**WELWYN HATFIELD BOROUGH COUNCIL  
EXECUTIVE DIRECTOR - PLANNING, PUBLIC PROTECTION AND GOVERNANCE**

**DELEGATED APPLICATION**

**Application No:** 6/2017/1364/PN8  
**Location:** 397 St Albans Road West Hatfield AL10 9RU  
**Proposal:** Prior approval for the erection of a single storey rear extension measuring 4.5m in depth, 3.6m in height and 2.55m to the eaves.  
**Officer:** Ms L Hale

**Recommendation:** Prior Approval Refused

| STATUS:<br>PRIOR APPROVAL<br>PLANNING | SIZE:<br>A3   | DRAWING. No.<br>MDHA/0617/01 |

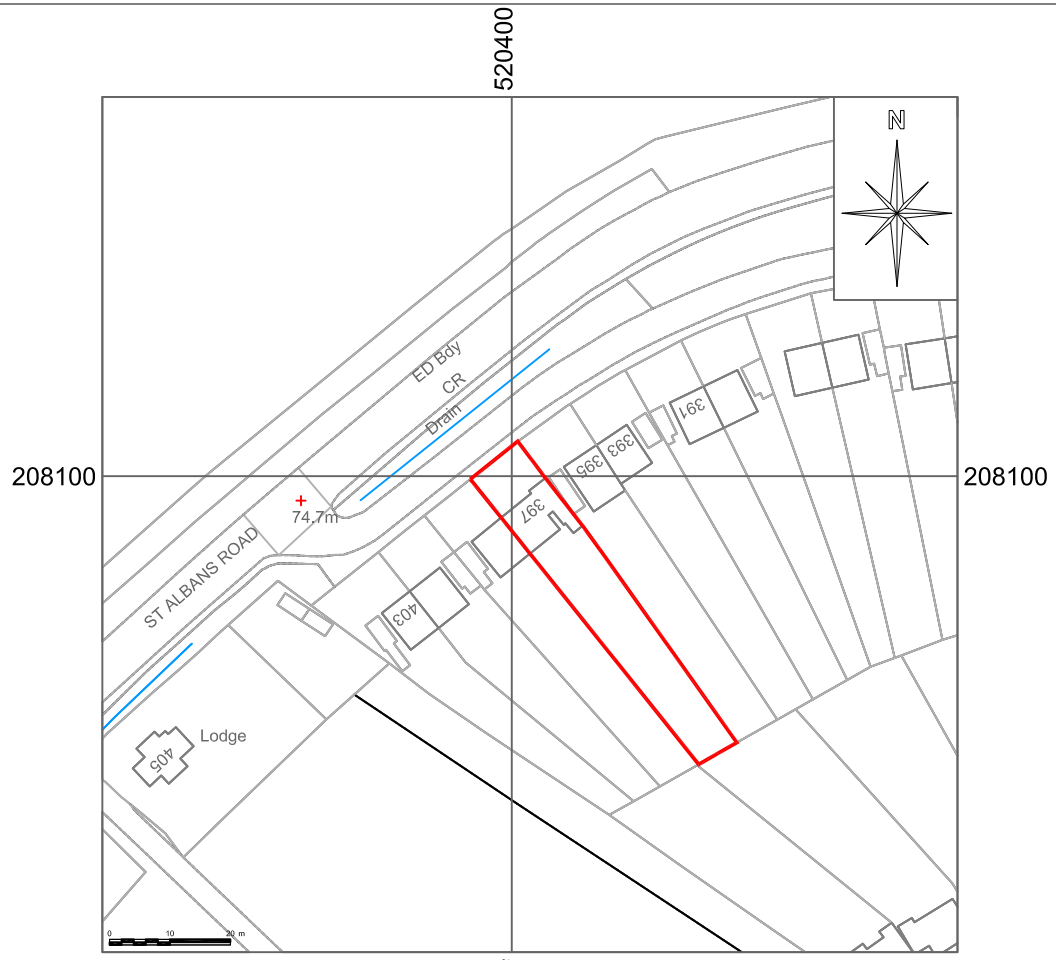
In this instance, as the proposed extension would join to an existing extension, it is important to firstly assess the proposed extension and then subsequently, the combined structure. When assessing only the proposed extension, it is noted that this would meet with the relevant limits and conditions of A.1 (e) to (j), however, when assessing the proposed extension and existing extensions as a combined structure in line with the amendments to Class A of the GPDO 2015, the proposal would fail to comply with A.1 (ja). Using the plotting sheets, it is evident that the original property did not benefit from a garage attached to the side of the property. Therefore, as the proposed extension would attach to an existing side extension, the combined structure would have a width greater than half that of the original dwellinghouse. The proposal would exceed the limits set out in paragraphs (e) to (j) would therefore fails to comply with A.1 (ja).

Accordingly, whilst no objections have been received from neighbouring properties, the proposal is not permitted development by Class A. Accordingly, the application for prior approval is refused using the powers transferred to the Local Planning Authority under Paragraph A.4(3)(a) of that Order as the development fails to comply with the conditions, limitations or restrictions applicable to development permitted by Class A.

1. The total enlargement (being the enlarged part together with any existing enlargement of the original dwellinghouse to which it will be joined) would exceeds the limits set out in paragraph A.1 (e) to (j) and therefore fails to comply with paragraph A.1 (ja) of Schedule 2, Part 1 of the Town and Country Planning (General Permitted Development) Order 2015. The application for prior approval is refused.
